**Consultation Response from Alan Smith,
KC Waste Strategy (Refuse & Recycling)**

**2025/91202 Unit 800, Bretton Park Industrial Estate, Bretton Park Way, Savile Town, Dewsbury,
WF12 9BS**

**Erection of three storey office extension, alteration of hard surfaced area to car park, with
associated works including landscaping.**

Responding Ref: WPN 25 009

BIN STORE DETAILS

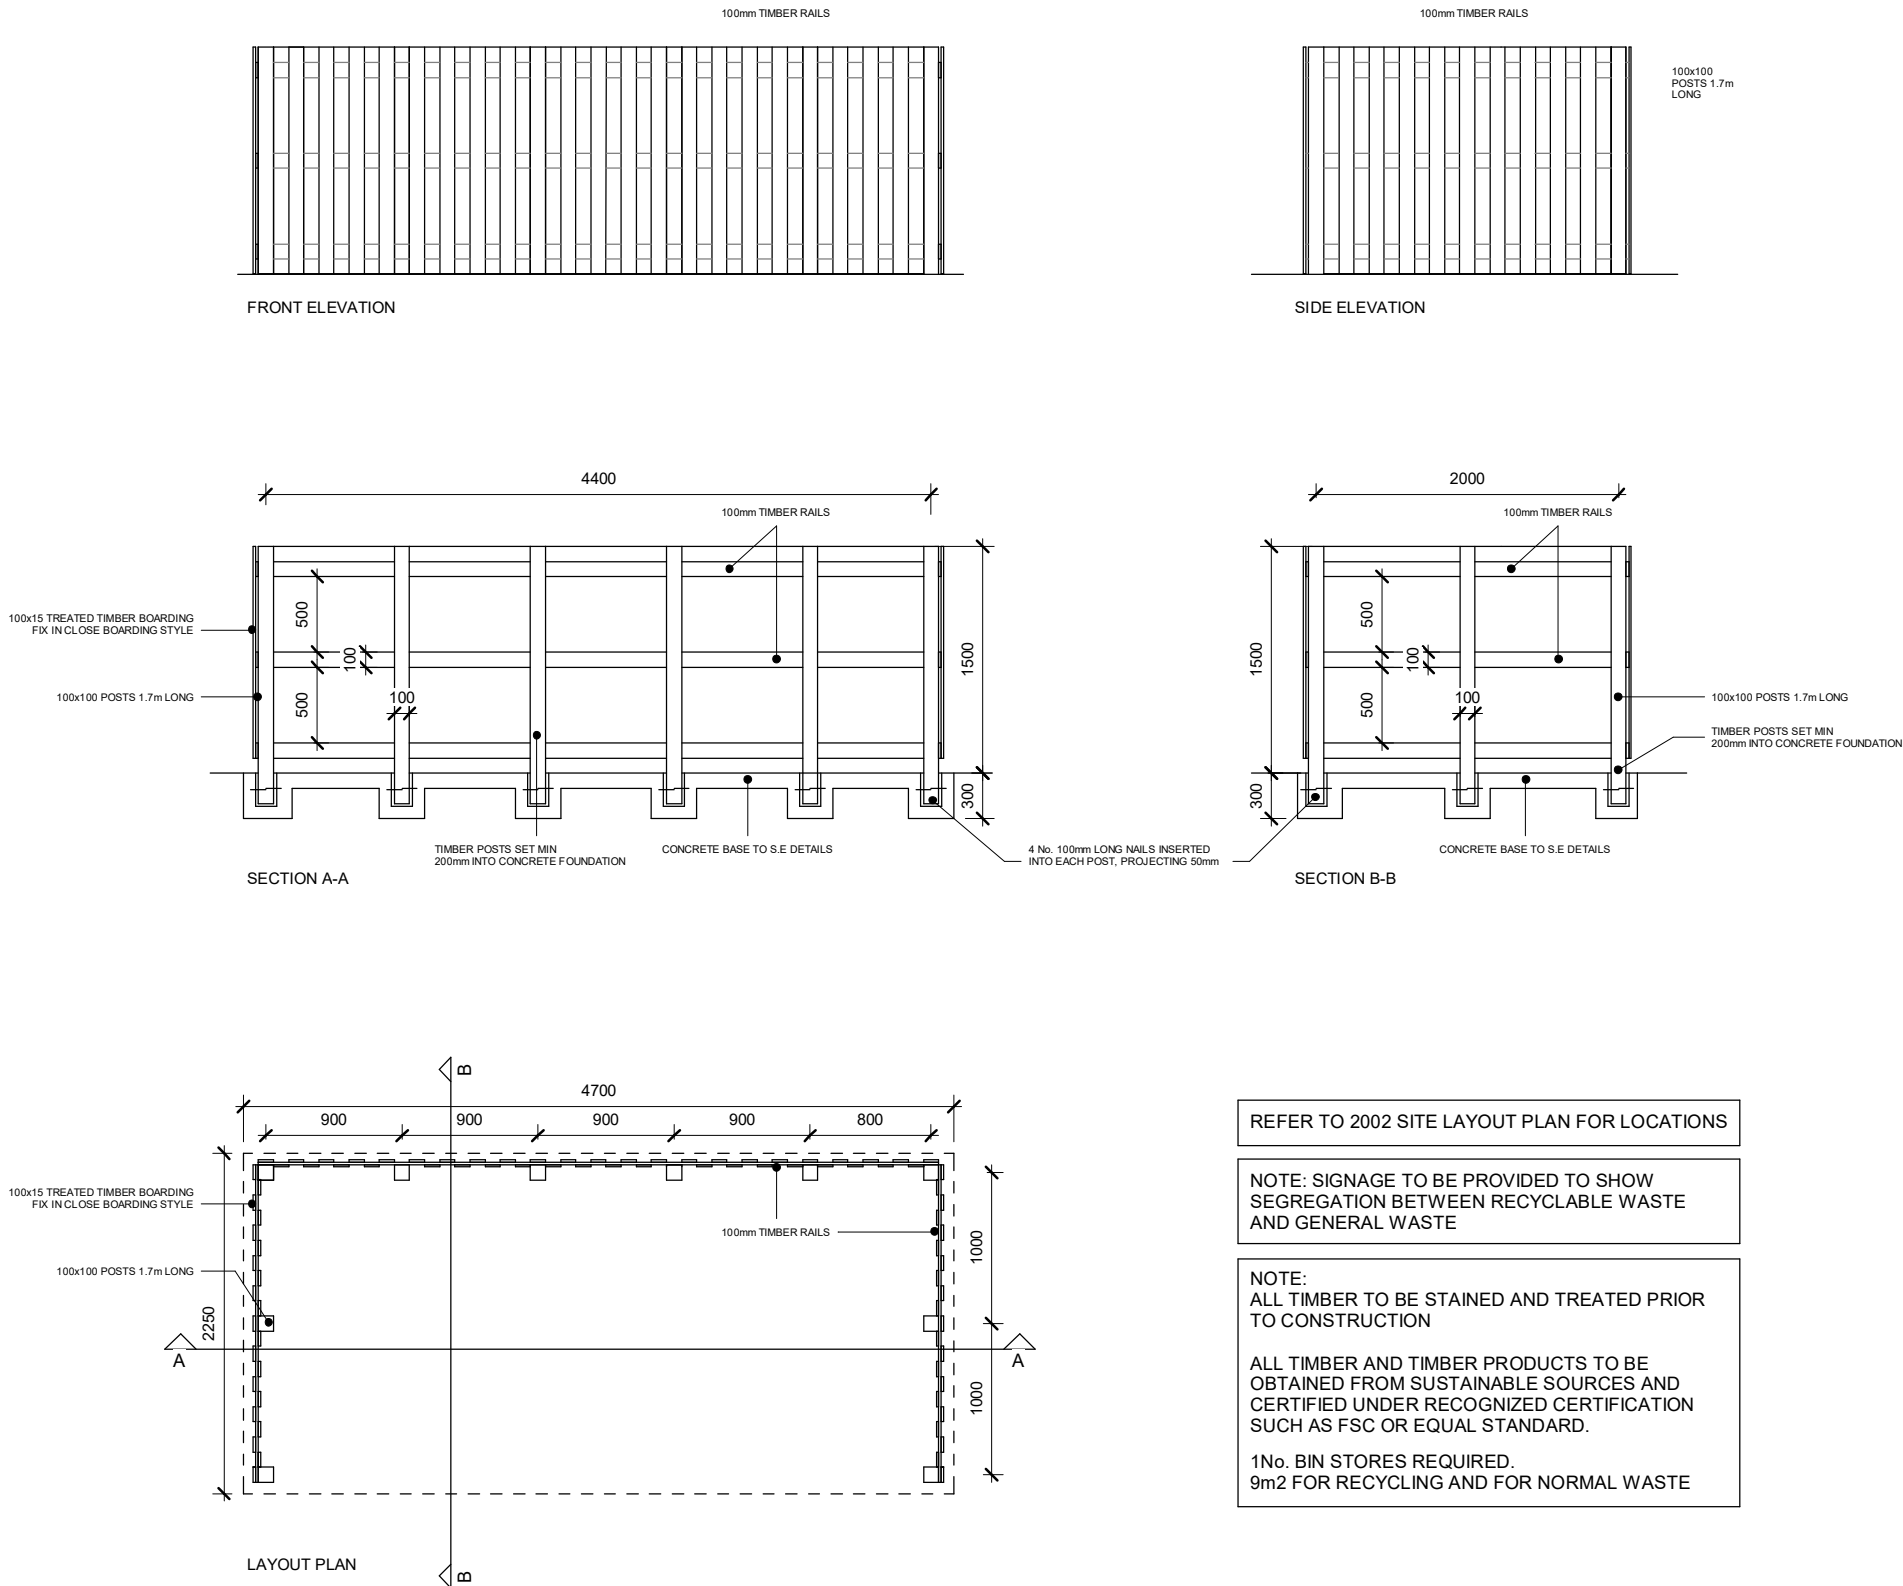
Waste management details for the site are contained in the document, “Grouped Plans and Elevations [id 1087578] Size: 87KB 01/05/2025 - 2013 BIN STORE DETAILS”. This document shows the proposed bin store, shown below.

The proposed bin store is of a size that will contain a wide range of suitable waste recycling containers.

- The bin compound shown in the southwest corner of the site is more than 6m away from the building. If not using skips or FELs, the drag out distance for wheeled bins from a bin store / premises to the collection vehicle should preferably be under 15m. Access to and from the bin storage area should be constructed to withstand point loading and movement, impacts of larger bins over time, and to resist future rutting, pitting, cracking or other such surface degradation that would impair bin manoeuvring. From the plan this looks like the bin store will be readily accessible with minimal drag out distances.

- There is an additional bin store shown for the office waste in the northeast corner of the site. The main issue with this location is that it is approximately 3.5m from the building. Ideally this should be extended to 6m due to potential fire risks. The bin store is of an adequate size to store a range of different types of waste container so should be acceptable. Access to and from the bin storage area should be constructed to withstand point loading and movement, impacts of larger bins over time, and to resist future rutting, pitting, cracking or other such surface degradation that would impair bin manoeuvring. From the plan this looks like it will be readily accessible with minimal drag out distances.
